Appeal Decision

Appeal Ref: APP/C3810/D/10/2134475

Thomas Cottage, Wepham, Arundel, West Sussex BN18 9RG

- The appeal is made under section 78 of the Town and Country Planning Act 1990 against a refusal to grant planning permission.
- The appeal is made by Mr David Bellman against the decision of Arun District Council.
- The application (Ref. B/14/10), dated 19 May 2010, was refused by notice dated 14 July 2010.
- The development proposed is the erection of a tree house in rear garden of property on a stilted platform.

NORTH ELEVATION AS PROPOSED

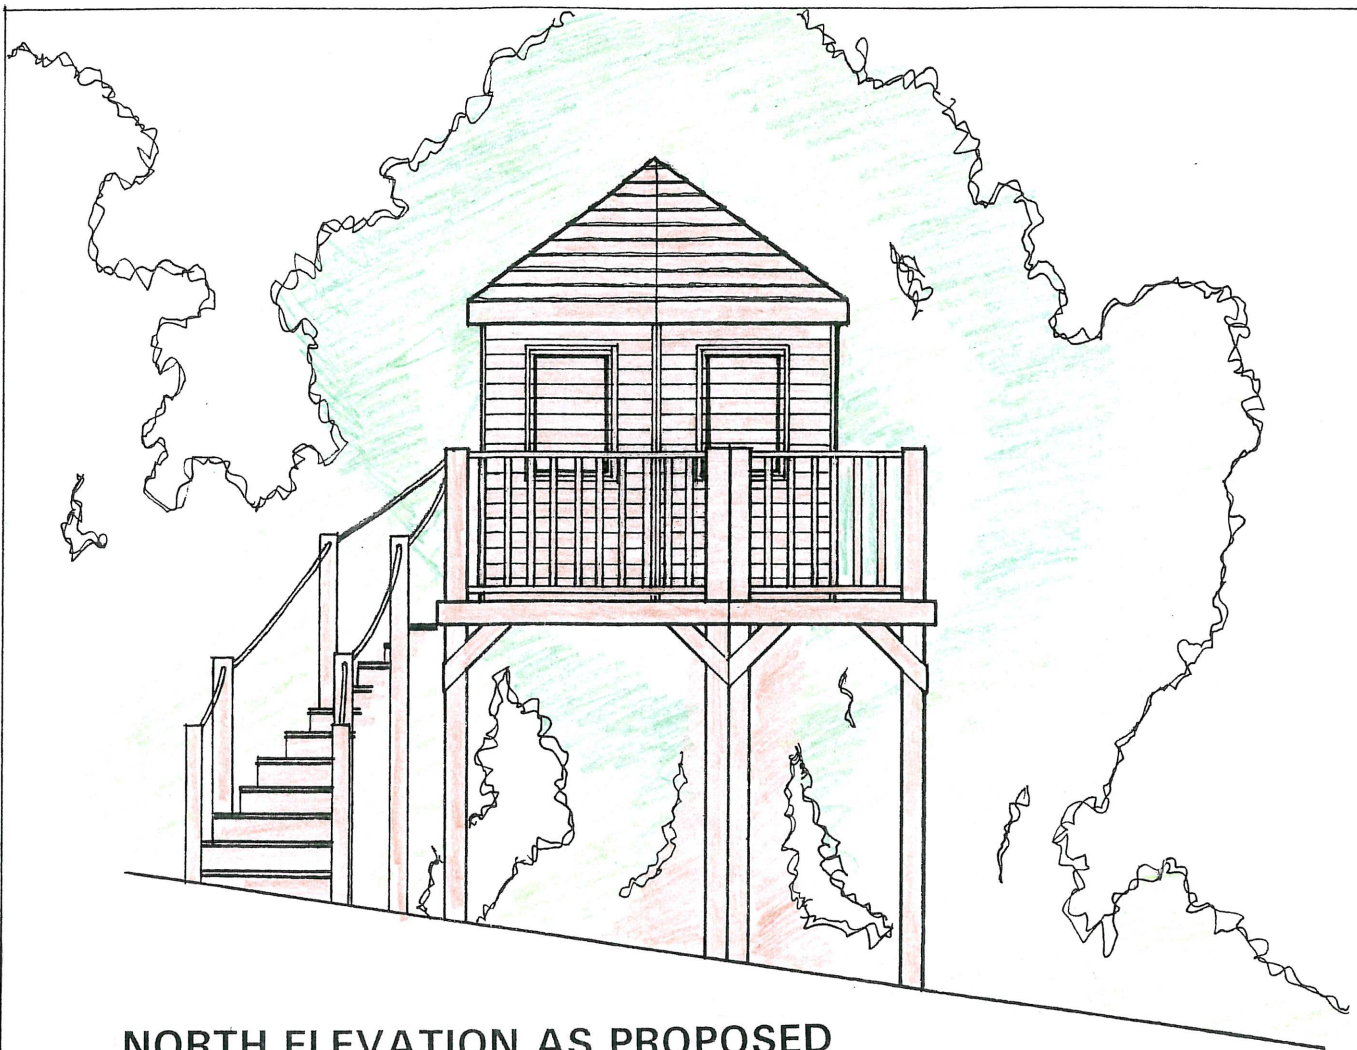
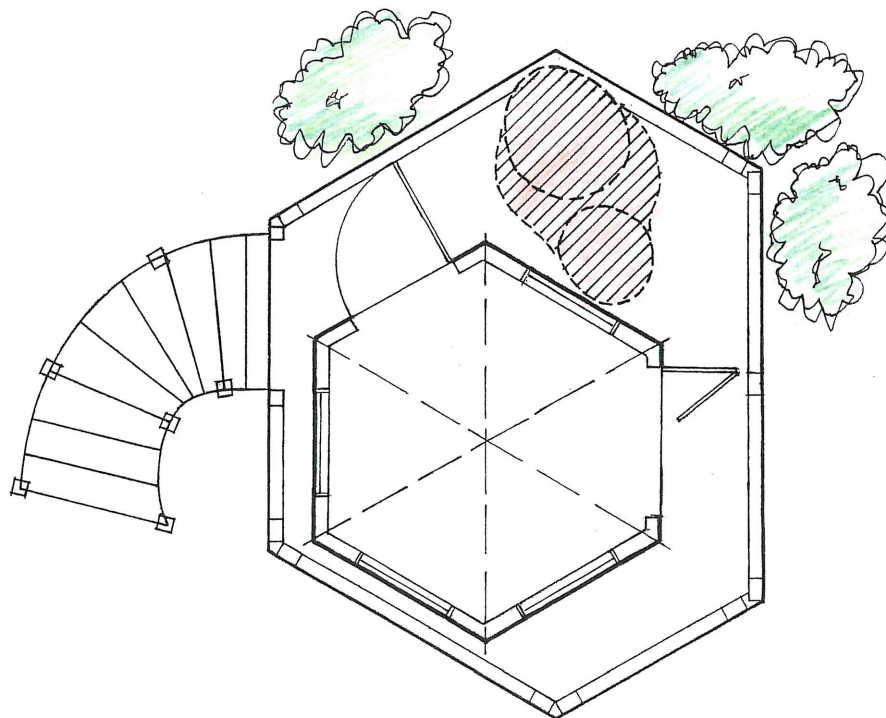
8. This proposal is not a whimsical, informal, rough timber, low key structure which one might imagine a tree house as being. It is a precisely constructed, regular shaped, smooth-timbered, pitched roof structure more akin to a suburban summer house. Furthermore, it does not rest comfortably within the boughs of a tree; rather it is elevated on precisely positioned stilts and partly surrounded by elevated decking. It is a masterpiece of construction, and I can entirely see its attraction to the appellant with the family fun element and sublime views offered across to Arundel, but sadly it is completely alien to its rural landscape setting. I do sympathise with the appellant over the time and trouble this construction has taken and the mis-understandings over permitted development, coupled with some officer encouragement which was seemingly given pre-application, however I do have to determine the scheme in the same way as I would if this proposal was on a plan, unbuilt.
